**Consultation Response from KC,
Conservation & Design**
2022/92883 and 2022/92882 - 749, New Hey Road, Outlane, Huddersfield, HD3 3YL
Listed Building consent for partial demolition, internal and external works and extension of an existing Barn to form 1no. dwelling
Conversion and extension of existing Listed barn to form one dwelling, part demolition and conversion of existing barn to form one dwelling and erection of one new-build dwelling with associated car parking and external works [Listed Building]
Date Responded: 15.11.2022
Responding Officer: Sebastian Pickles
Responding Ref:

Site Plan as Proposed

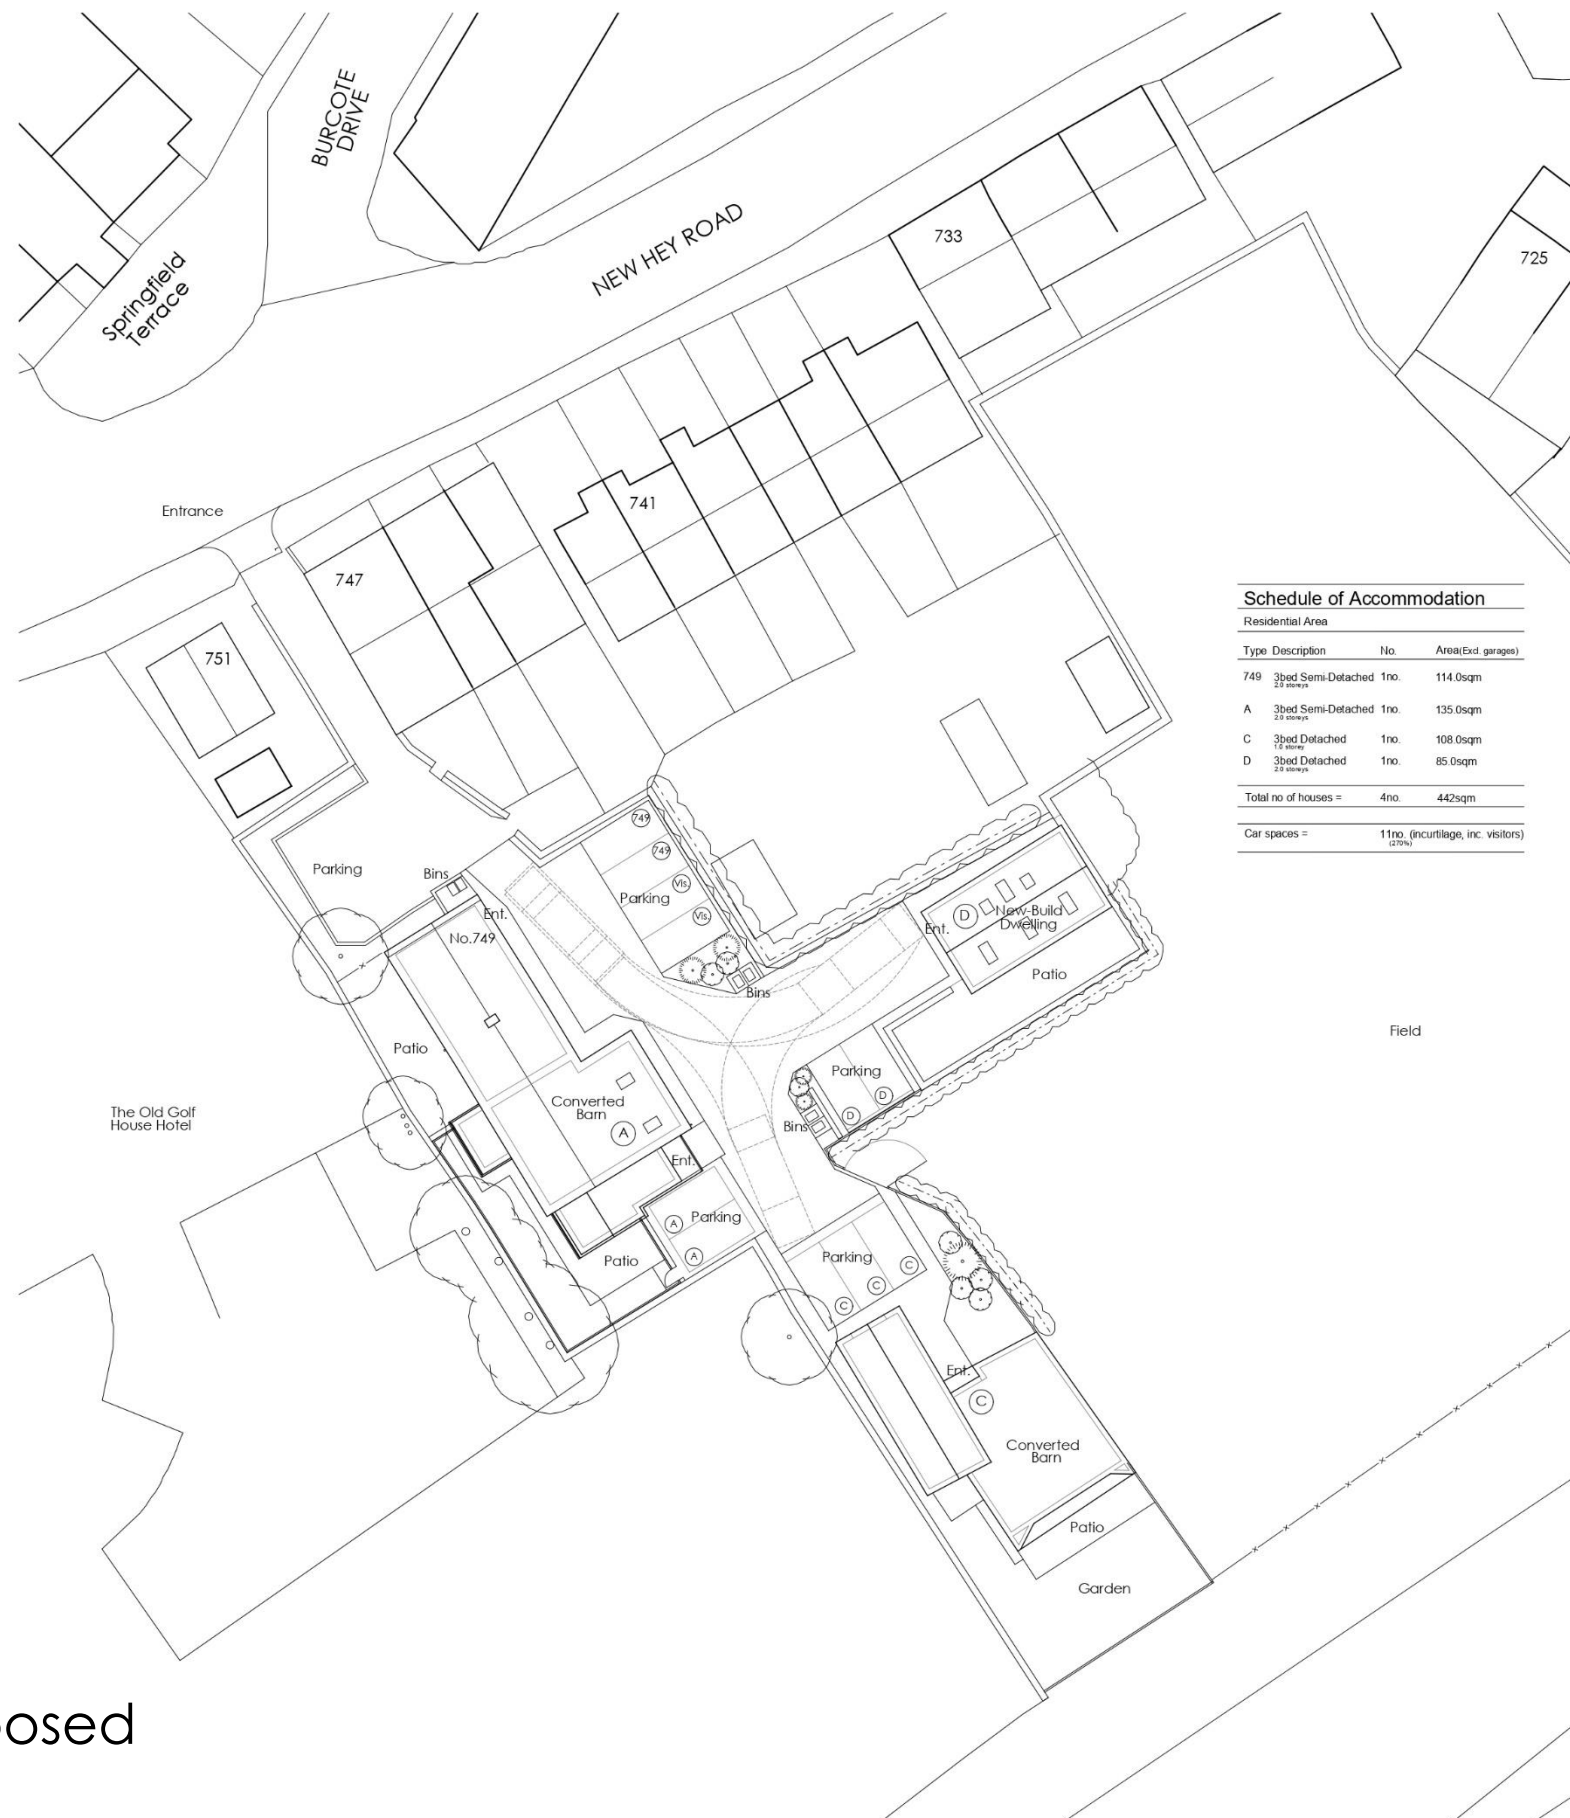
As to the proposed development to the east. This would see an entirely new structure erected, with surrounding stone walling and hard standing. We are not supportive of this element of the proposal, as it does not consider the setting of the Farmhouse and proposes development which fails to respect the setting of the farmhouse. We do not consider that with minor amendments to the design that the harm could be overcome and consider that this element of the proposals should be omitted from the scheme. There is no clear and convincing justification for allowing such development and we are unable to support this element of the proposals.
